Application no: **3/2022/0719**

Address: **Hillcrest Farm Startifants Lane Chipping PR3 2NP**

Proposal: **Retention of unauthorised siting of a Shepherds Hut for holiday accommodation and new access track.**

# SITE PLAN SCALE 1:500

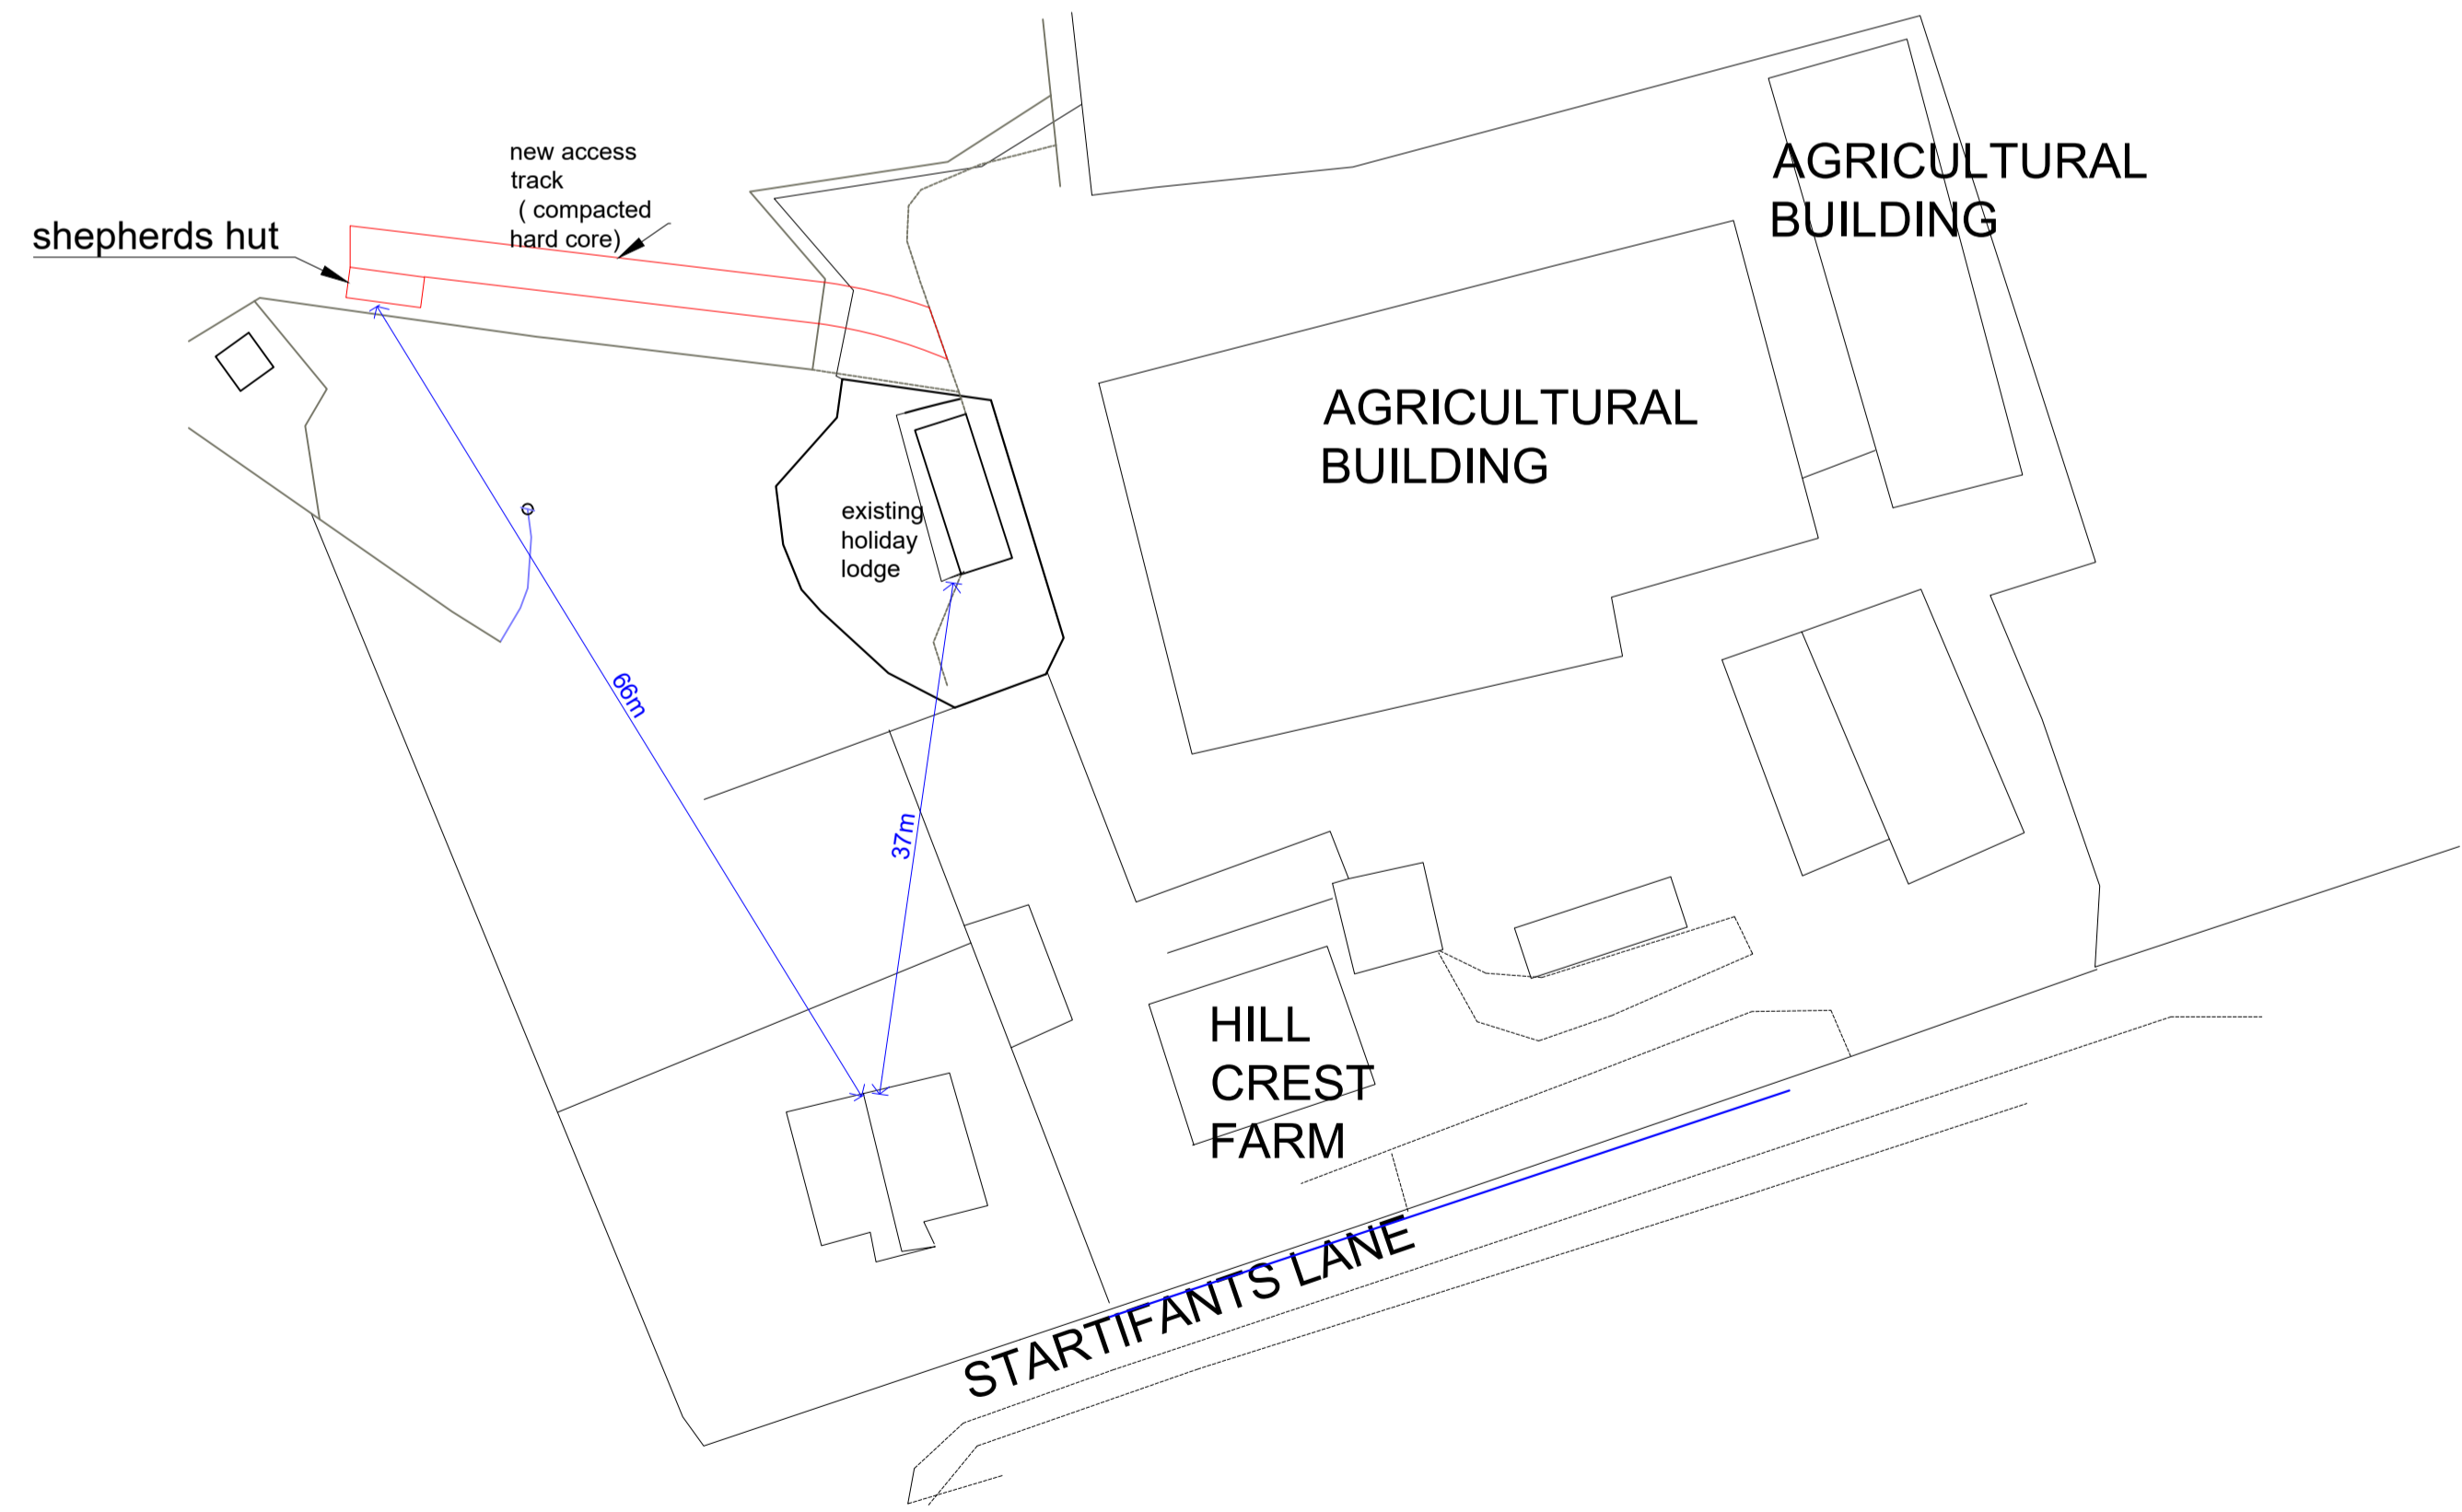
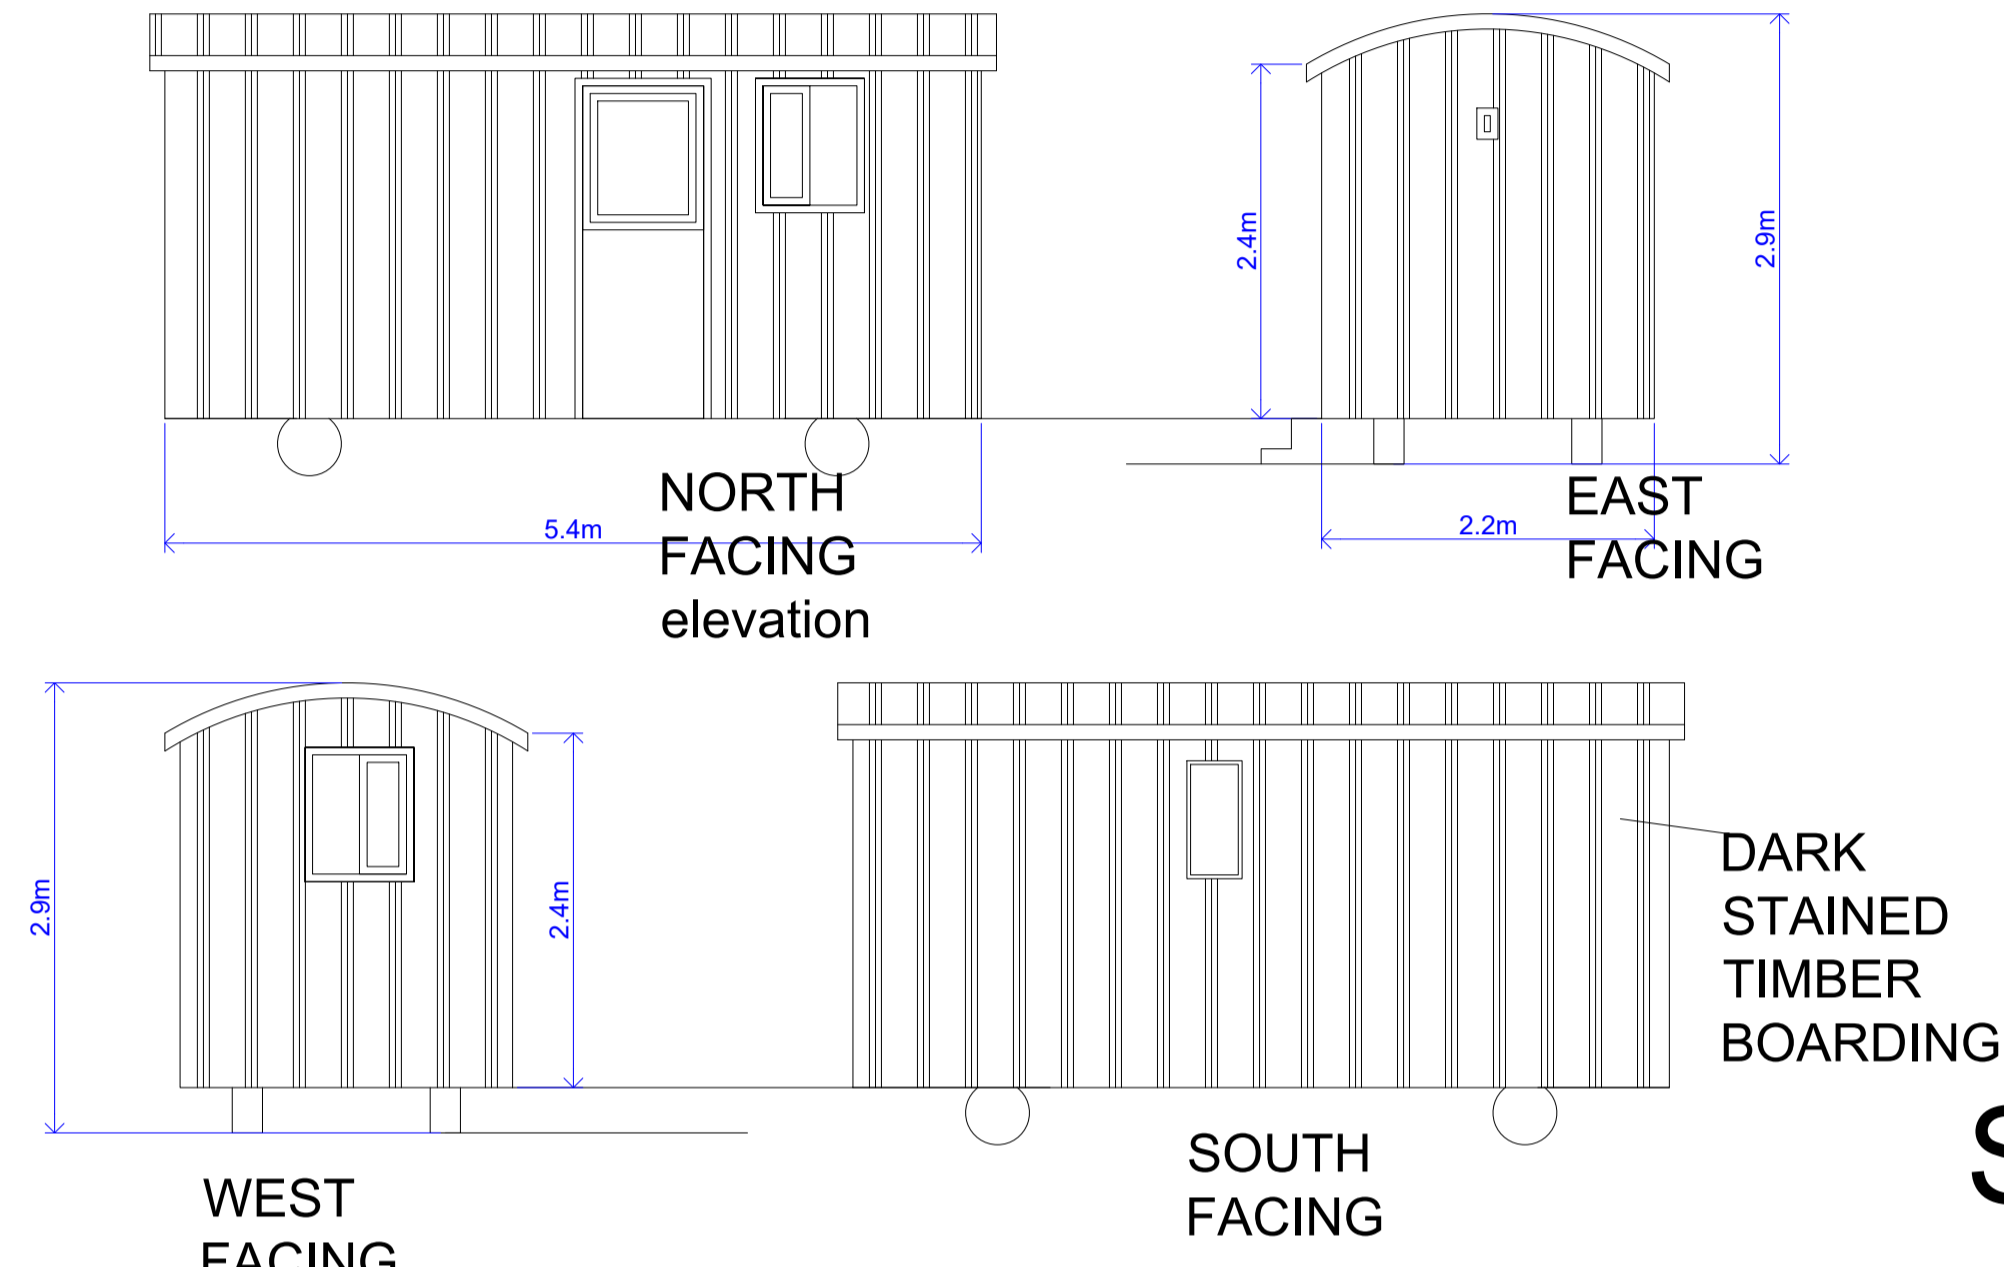
However, the supporting documents have not shown a parking plan for the holiday let.

The LHA do advise the Applicant to provide a designated parking area for the hut to prevent conflict with the operation of the farm.

The LHA have also reviewed the extension to the access track, as shown on ML drawing ML/SP/6127 and are aware that the track is the adequate width to serve the hut. Therefore, the LHA have no further comments to make.
